26 July 2021

Pre-application Advice

MONKS HALL, SYLEHAM, SUFFOLK

DRAWING
 Proposed Elevations Option 2

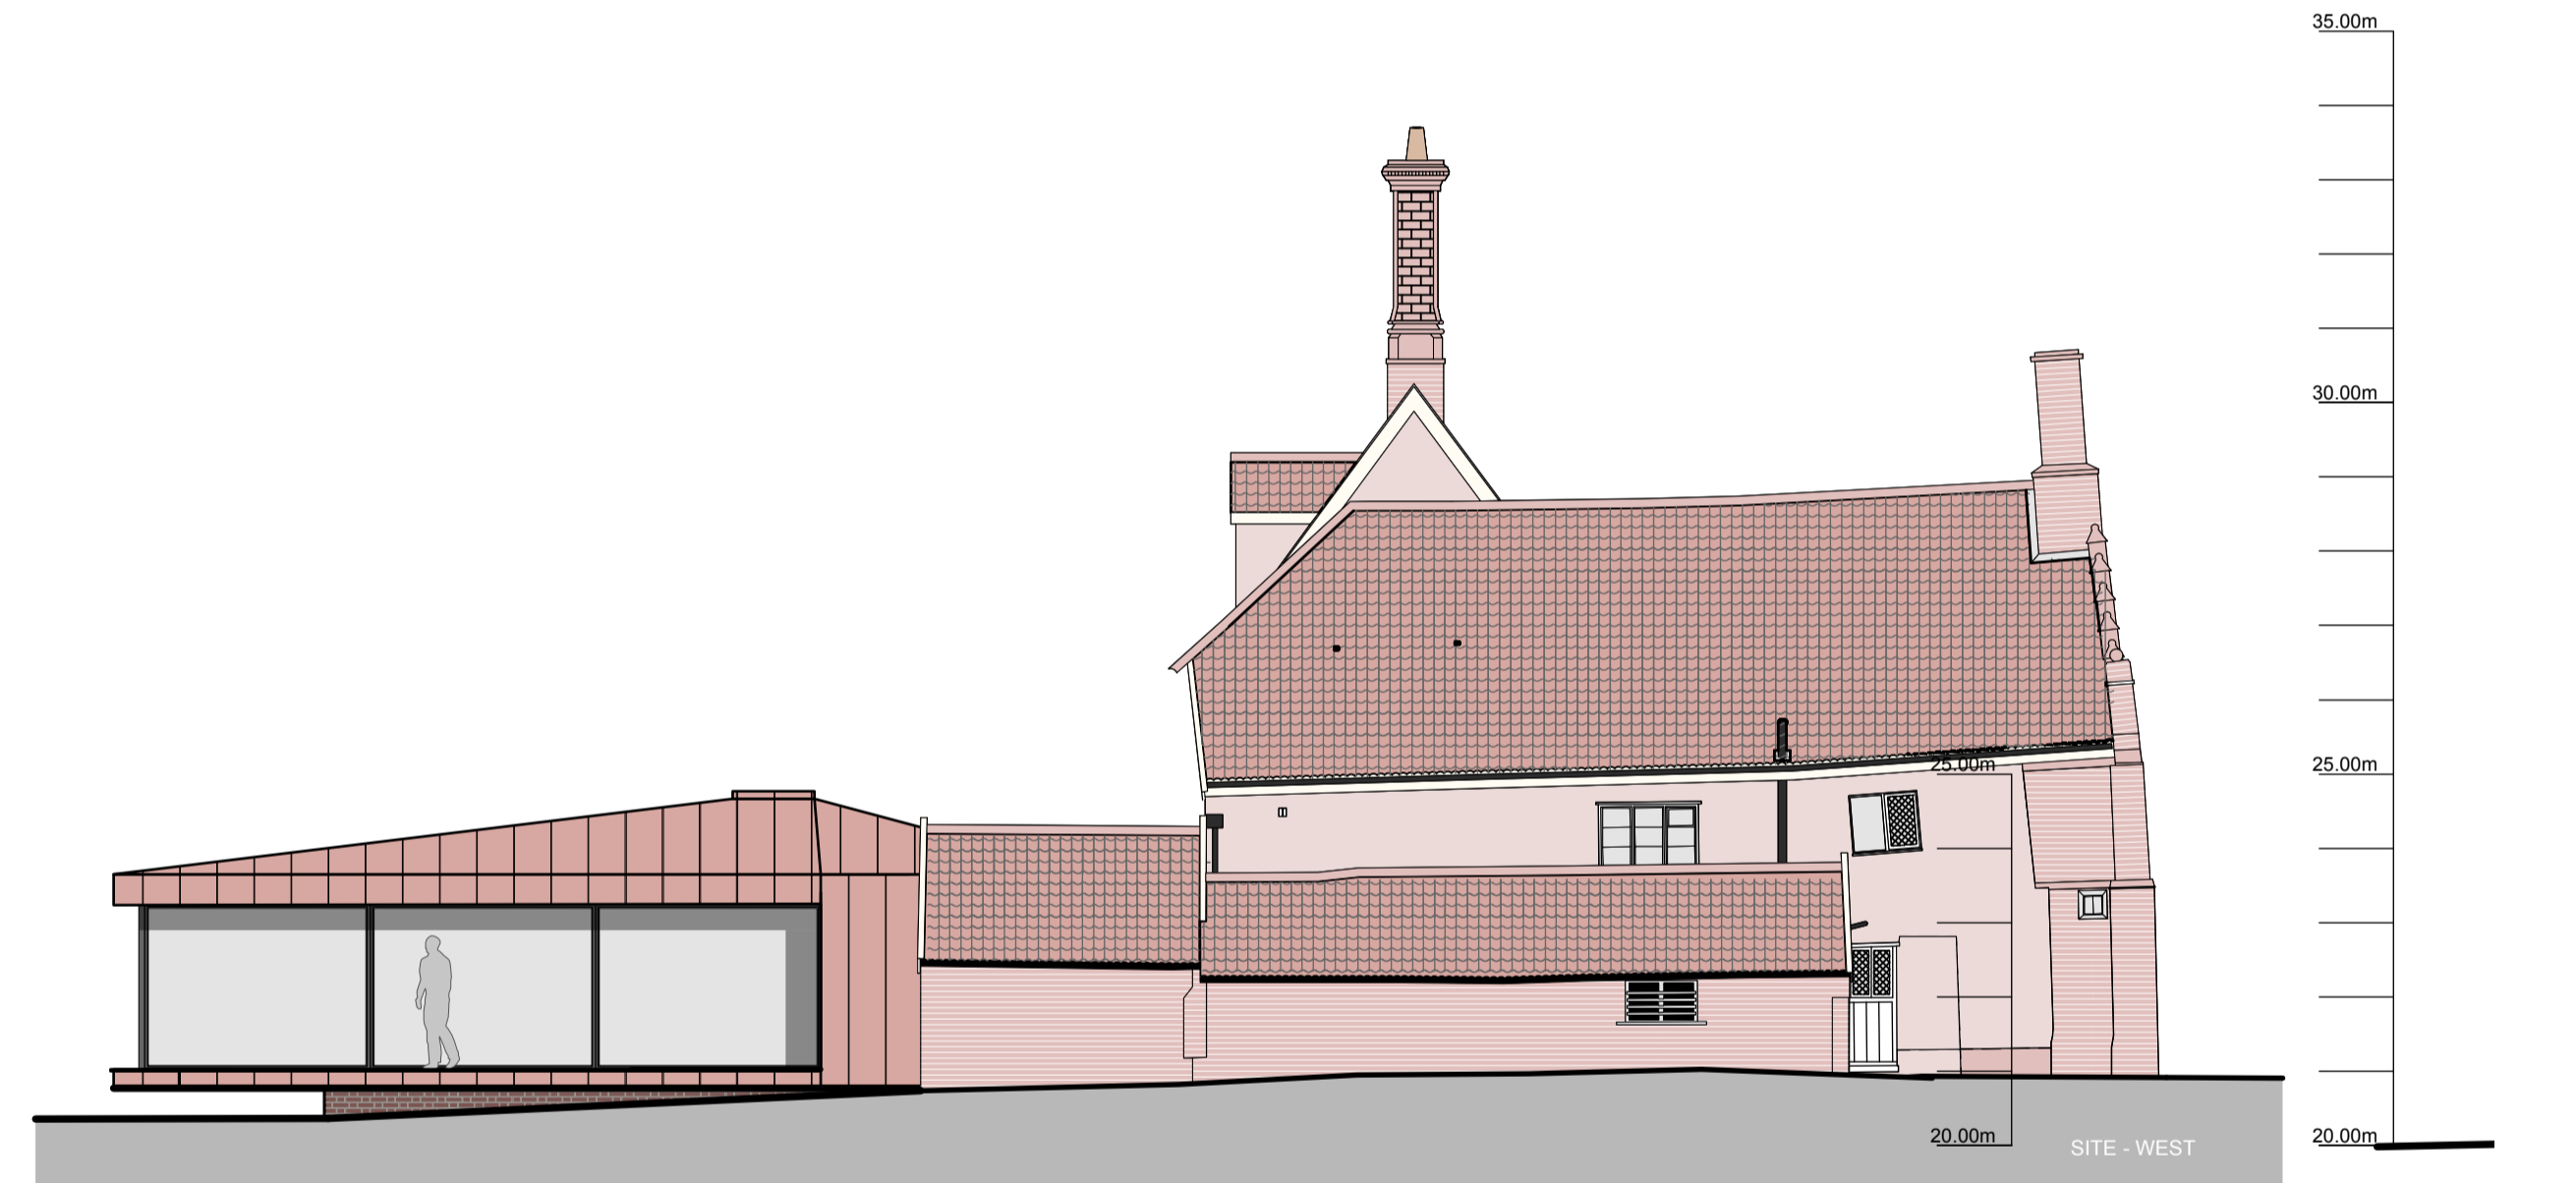
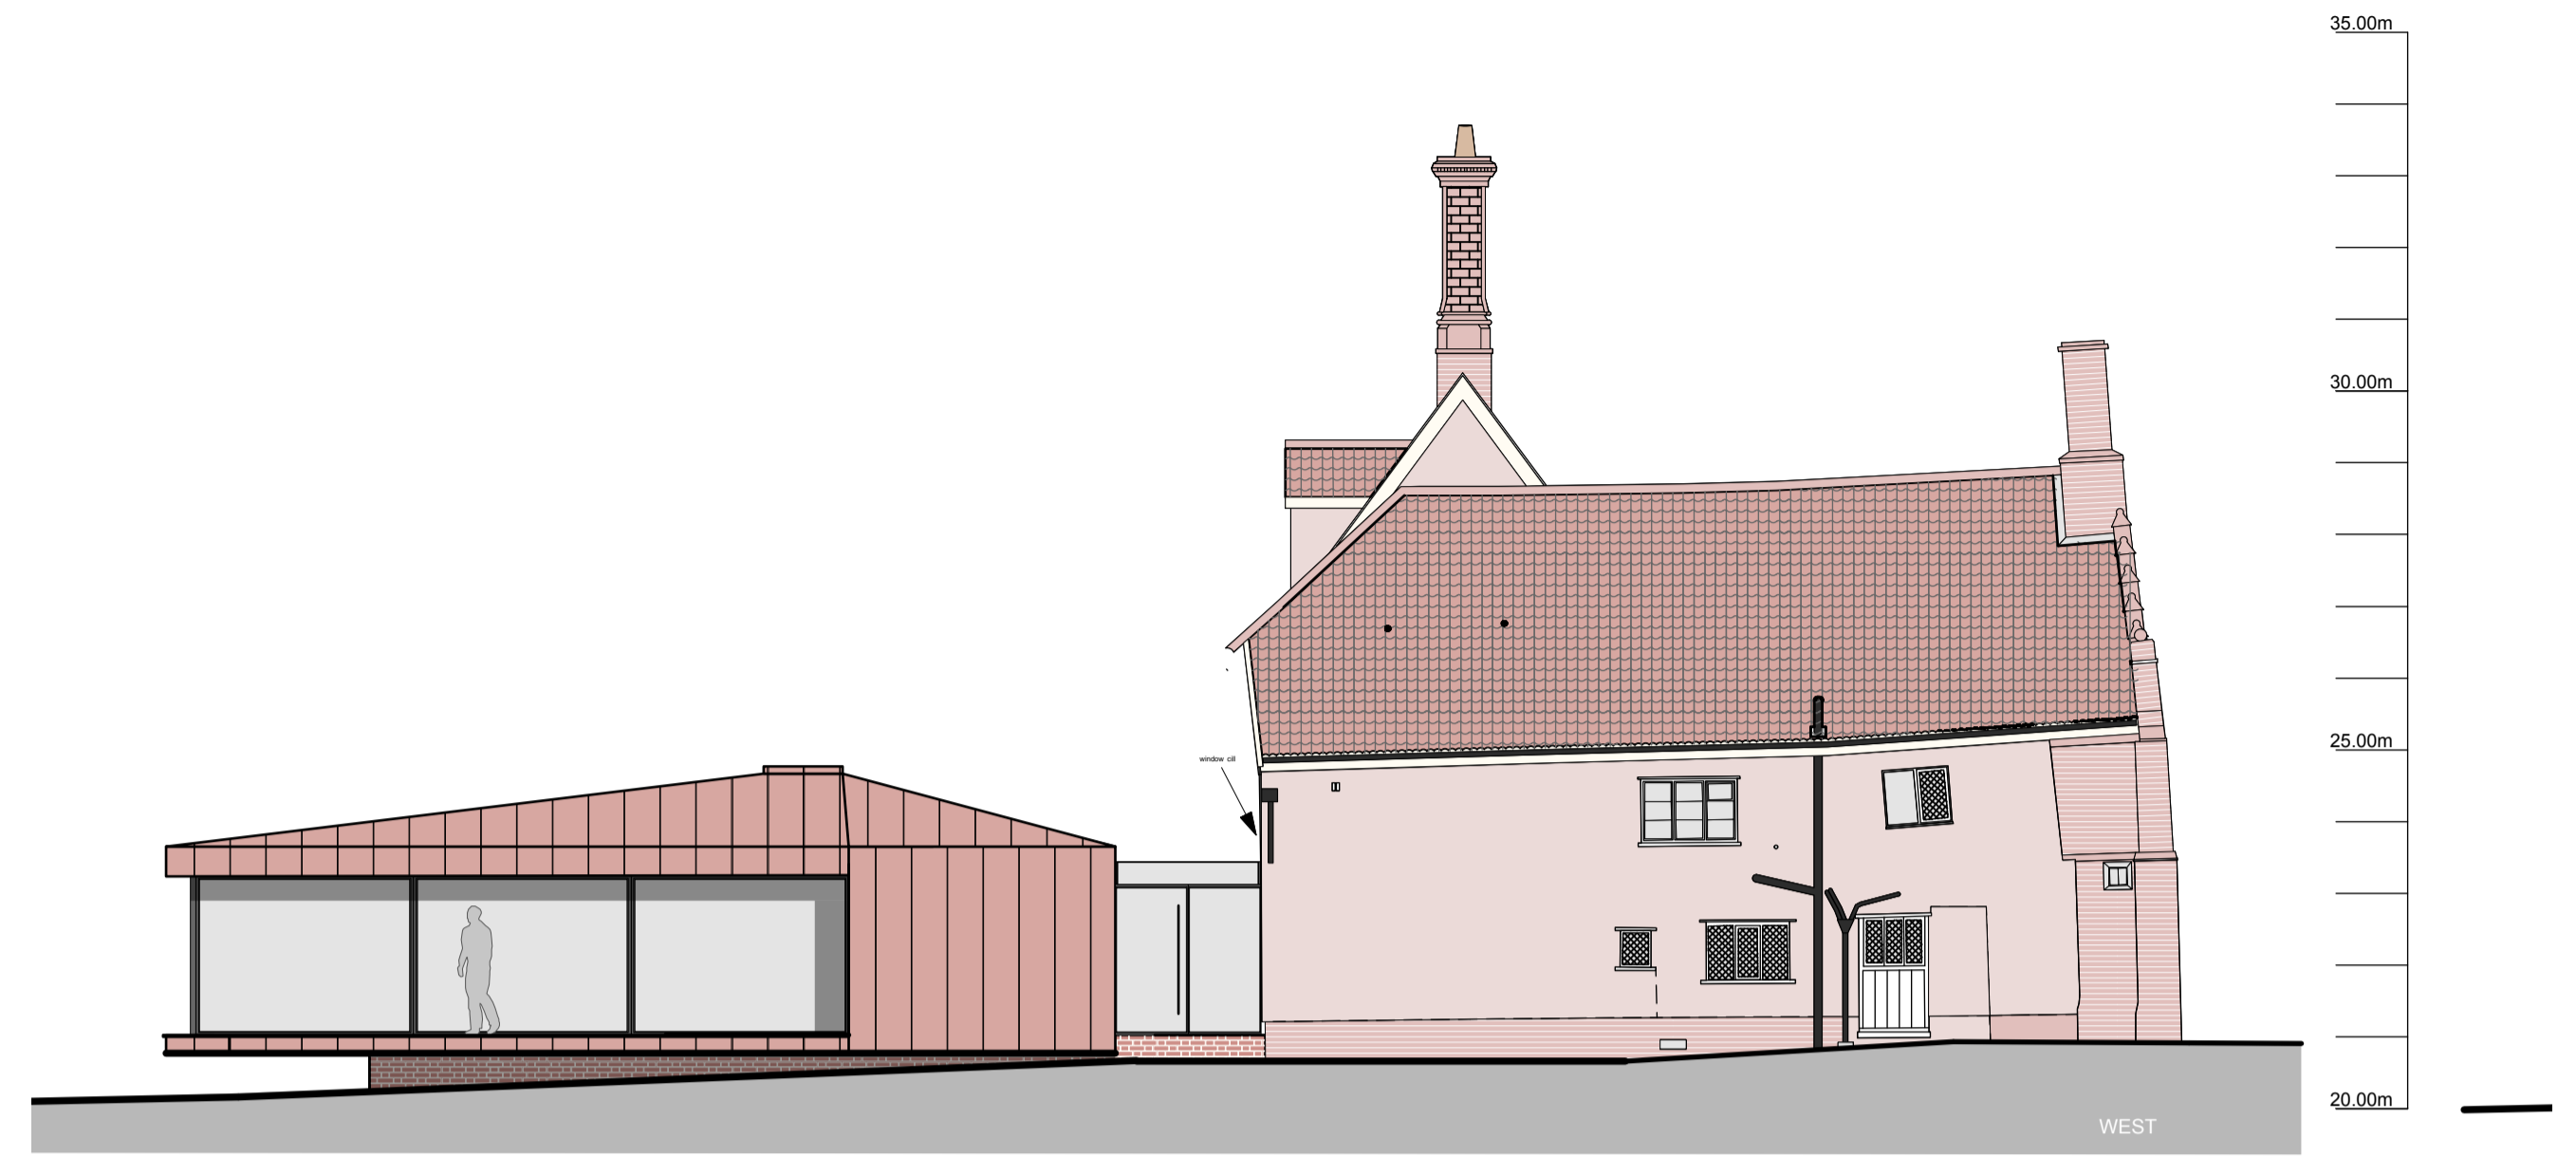
This element of the proposal has changed since the initial proposal which was wider and linked to the adjacent outbuildings. The long thin and modern nature of this proposal aims to have minimal visual impact upon the historic building and, through the provision of a fully glazed box will have minimal contact with the building. The removal of the flue from the 'nose' end of the proposal has improved the visual impact of the proposed extension. The materials proposed are modern metal cladding from VMZINC in Pigmento with the same colour seamed roof.

The proposal is strikingly different to the historic building in terms of its form and materials but it does not follow that this should mean it impacts negatively upon the building's significance. This will be determined by how it relates to the building and whether it can be accommodated without harm from other elements. Aside from the entrance to the space as raised above, the extension would provide single storey, kitchen and everyday dining facilities, sleeping and bathroom arrangements are retained within the historic space. The success of the scheme would hinge on the quality of the design and materials and whether a fully glazed link can be properly and appropriately designed and detailed.

The loss of the existing lean to extension and chimney should be appropriately justified and all comments above are dependant on this being able to be done.
